Alison Smith Chair
Somerton Parish Council
C/O 2 Troy Cottage, Somerton, Bicester, OX25 6NG
4 June 2020

Application Number 18/00825/HYBRID

Somerton Parish Council has the following comments to make regarding the Masterplan

FIGURE 6.2a
PEDESTRIAN AND CYCLE CONNECTIONS
 27/02/2020
 SCALE: NTS @ A3

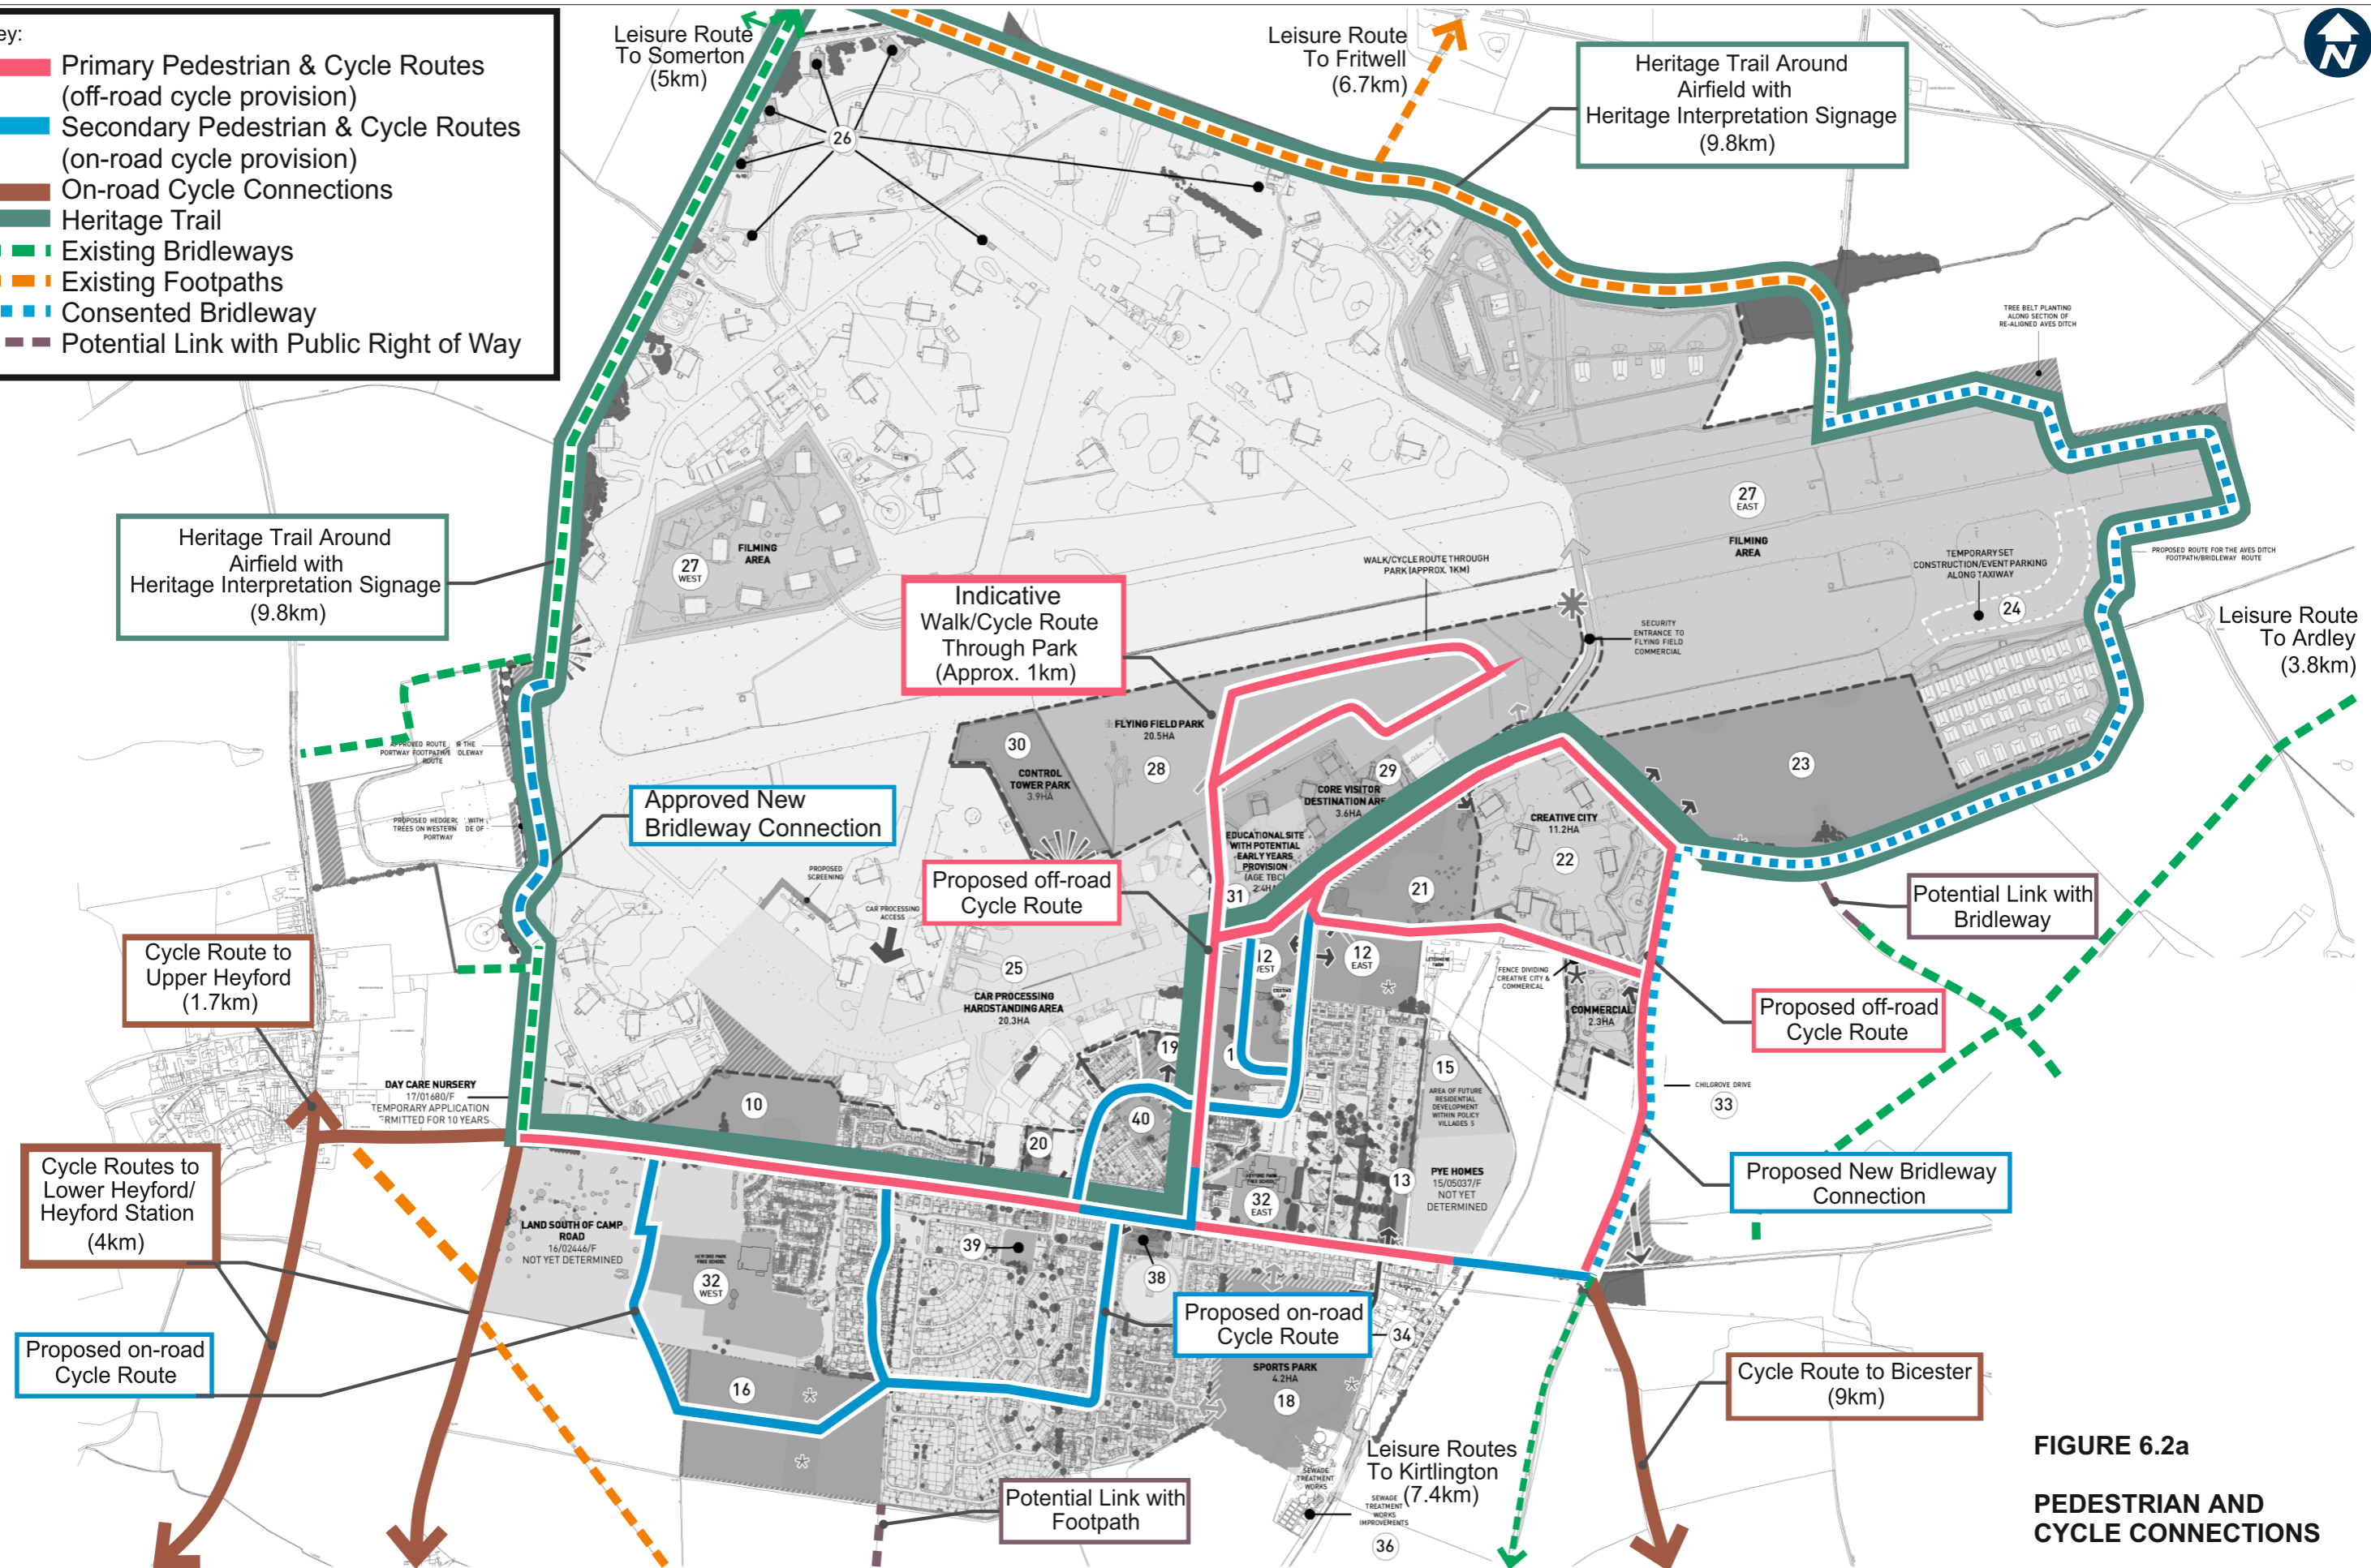
- c. **Leisure Route to Ardley** **FIGURE 6.2a** suggests a Leisure route to Ardley utilising a marked Bridleway. Somerton PC support the opening up of these routes! However you must know this route is not safe for walkers and impassable for horse riders. As it crosses the railway on the very busy B430. Is it the intention to make this route accessible for horses and will there be funding for this? As this route is not currently functional as a bridleway, (see photos from 1 June 2020 below) and even dangerous for walkers. The bridleway crosses the railway on the very busy B430 but the access from the gate is impossible on horseback and very difficult on foot as it is blocked by Armco barrier and overgrowth. After navigating the busy B430 bridge (on horseback *(assuming you have a steady Eddie that can navigate the 4' Armco and turn on a sixpence to avoid oncoming lorries)* –with current traffic levels and speeds this of course would be impossible. The Bridleway then leaves the highway and runs parallel to the railway on the Ardley side towards Ardley wood. This is not accessible by horse riders as the only way through is over 3 styles and overgrown tracks. The bridleway runs through the BBOWT nature reserve and the track is totally impassable on horseback. For it to be a viable bridleway and “Leisure route to Ardley, another route needs to be found away from busy traffic on the B430. **Somerton PC request for funding to re-route this bridleway to the other more suitable bridge just a little north near to the "earthworks" (fig 1).** This would be far more economical than trying to make the current Bridleway useable and only requires a small change.
